Sent: 21 June 2019 14:54
To: Zac Denton
Subject: RE: CM/17/19/HH - 35 May Close, Climping

Subject: CM/17/19/HH - 35 May Close, Climping

Drawing no. **CP/MC/02**

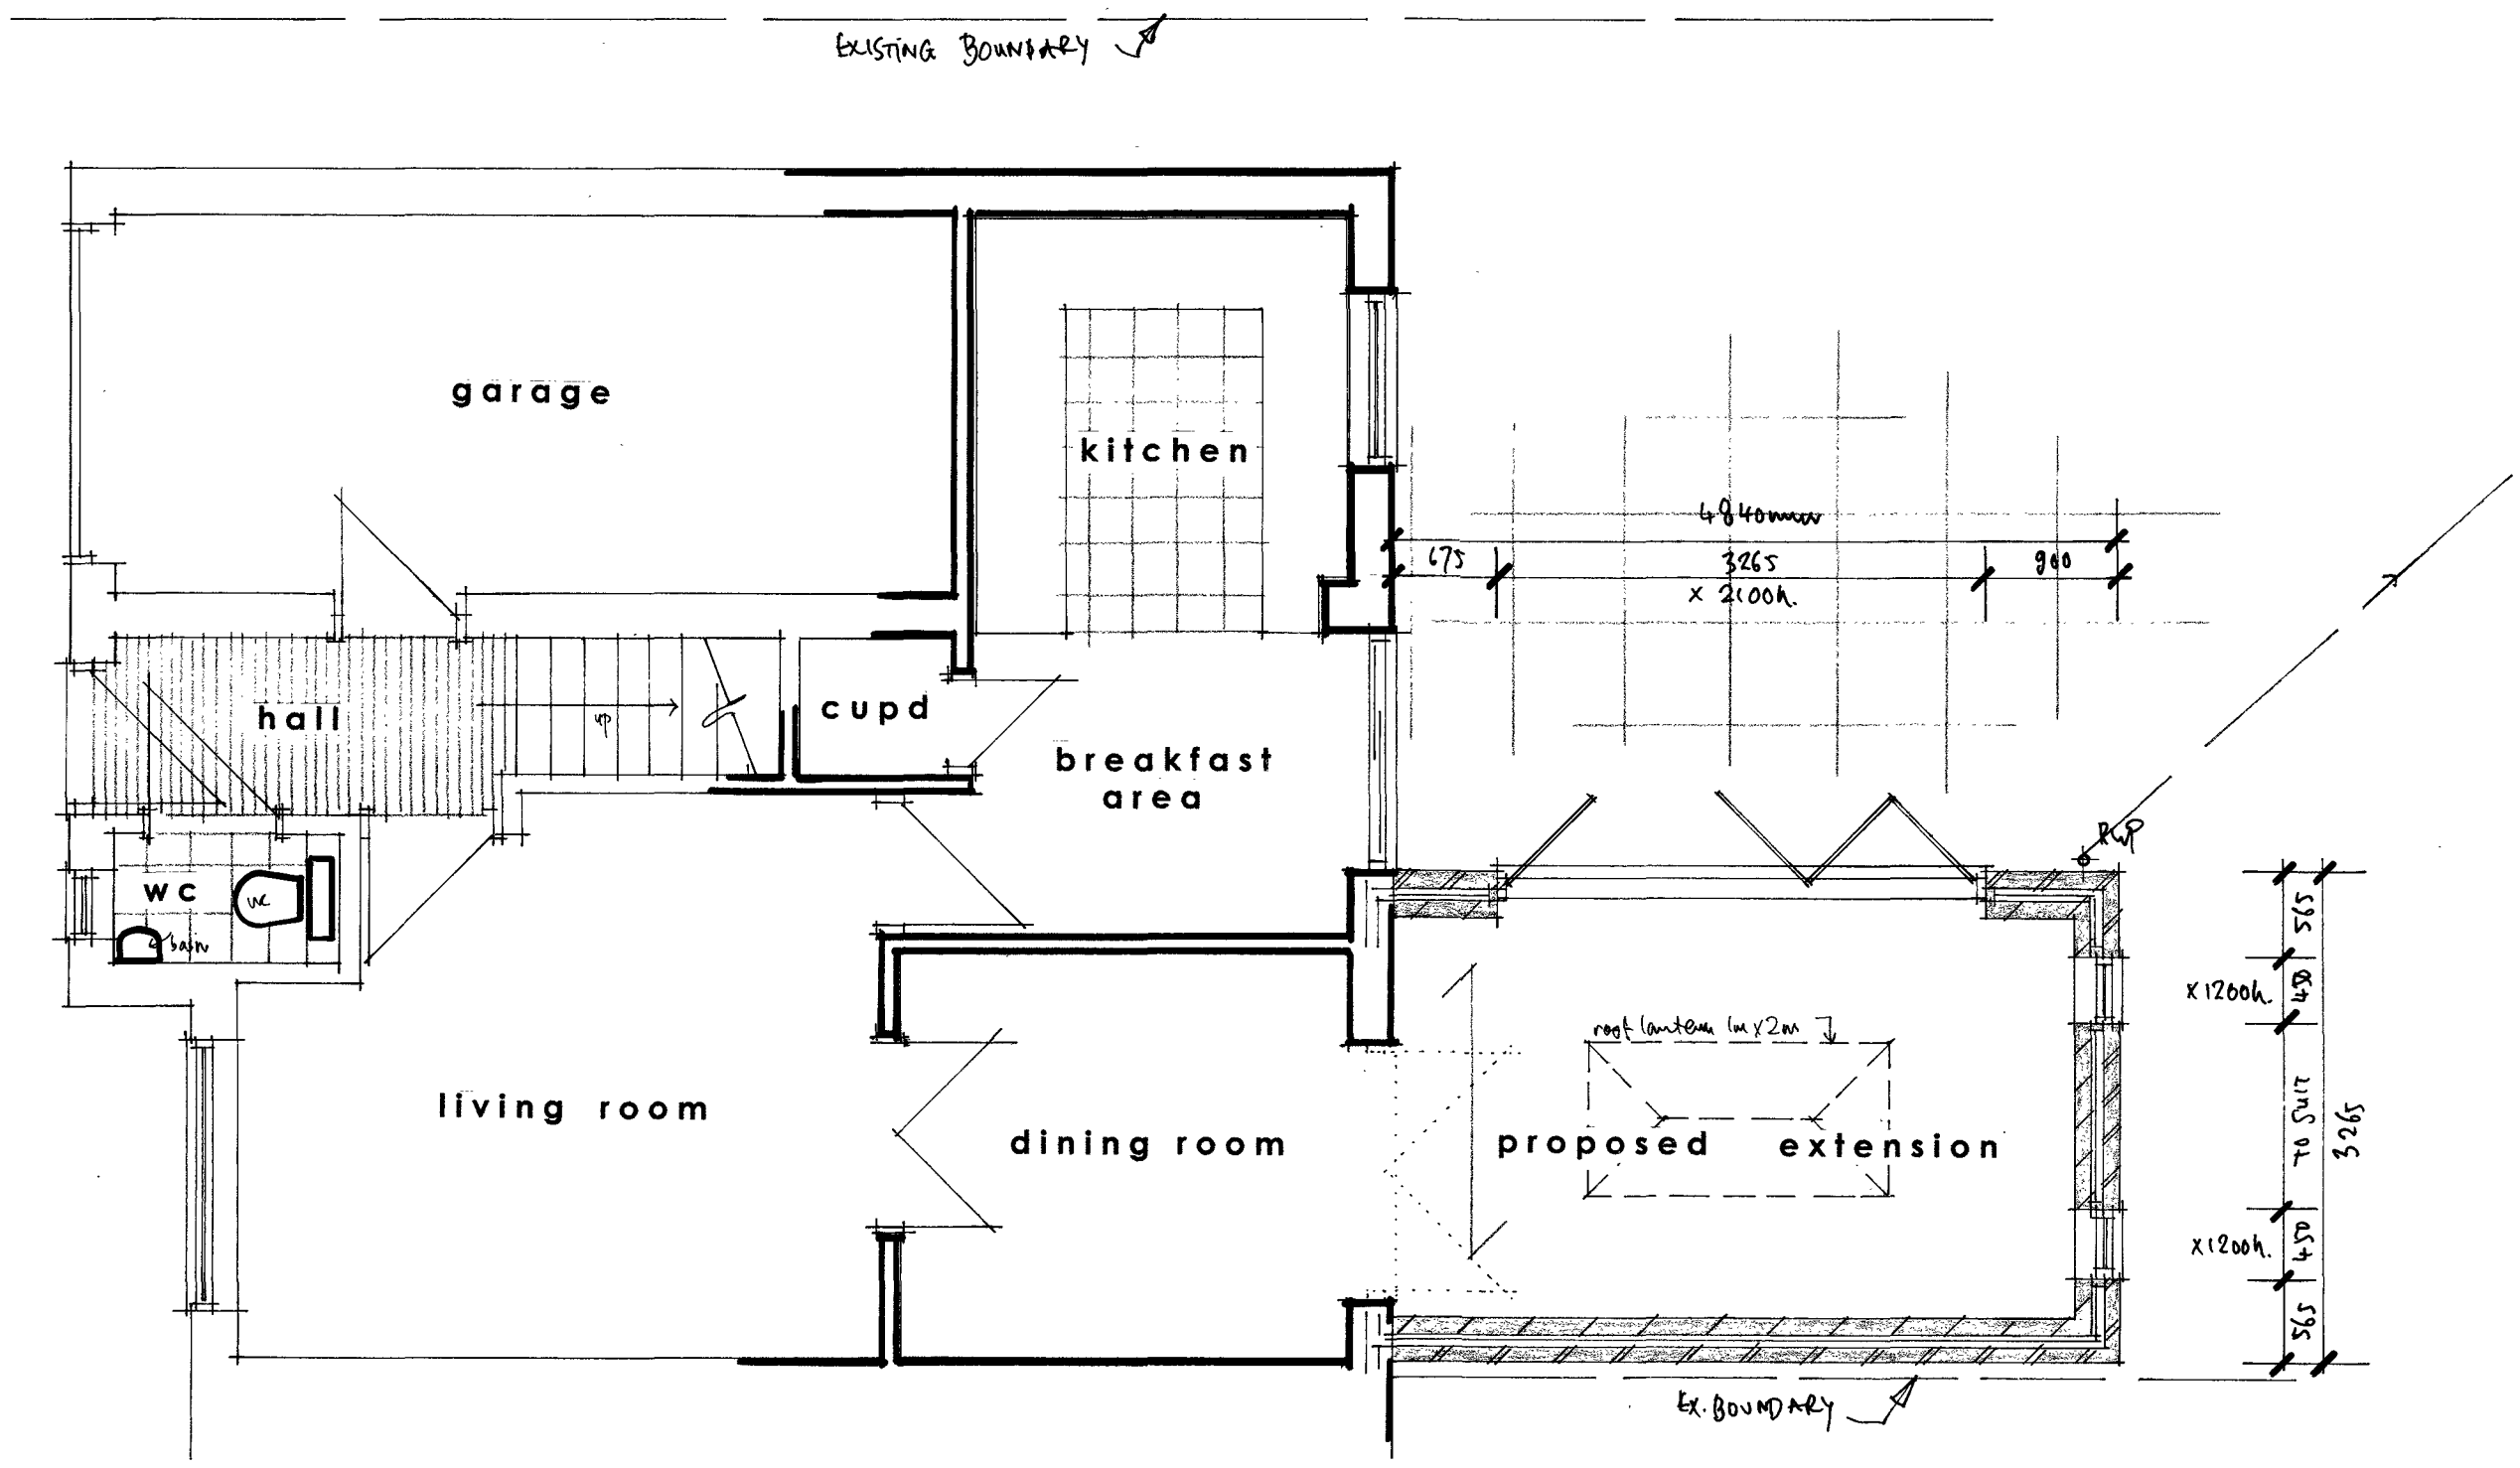
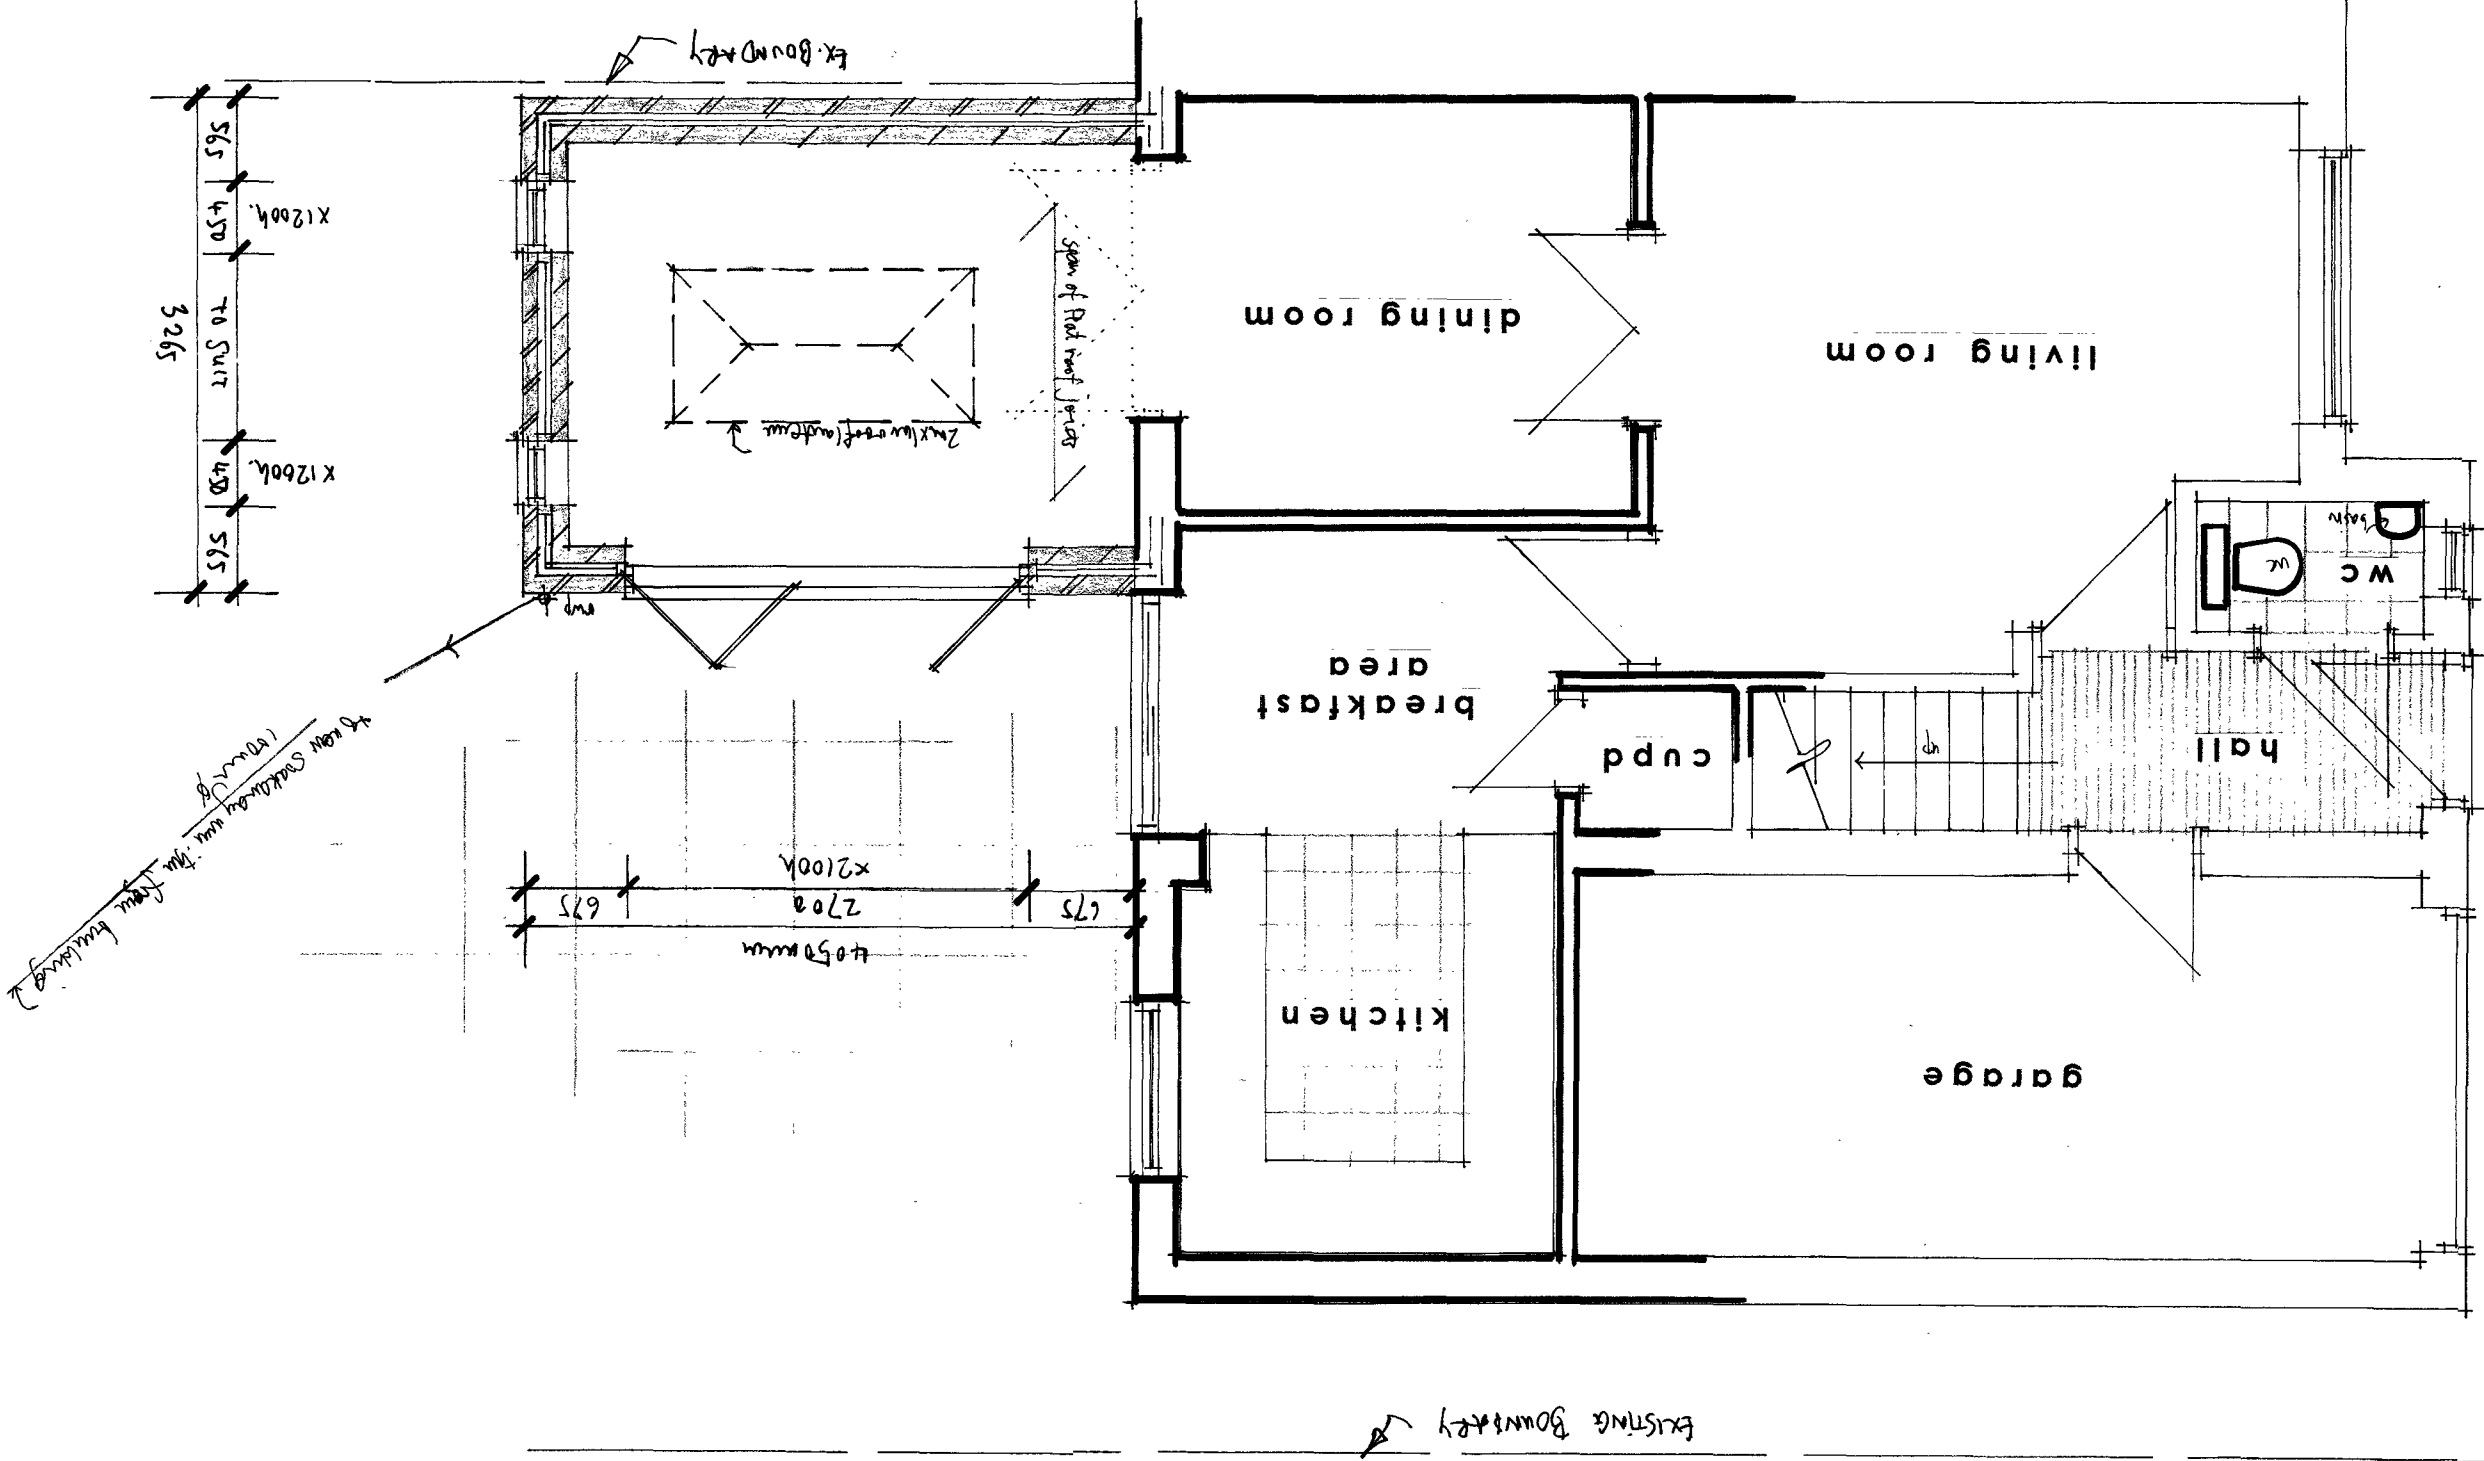
As discussed, the Council currently has concerns relating to the bulk of the proposed extension, would you be agreeable to an Extension of Time until the 20th of June in order to make amendments to the application?

Dear Zac,
Amended drawing attached showing the extension reduced from 4.84m down to 4.05m as agreed.
Regards.
Wayne
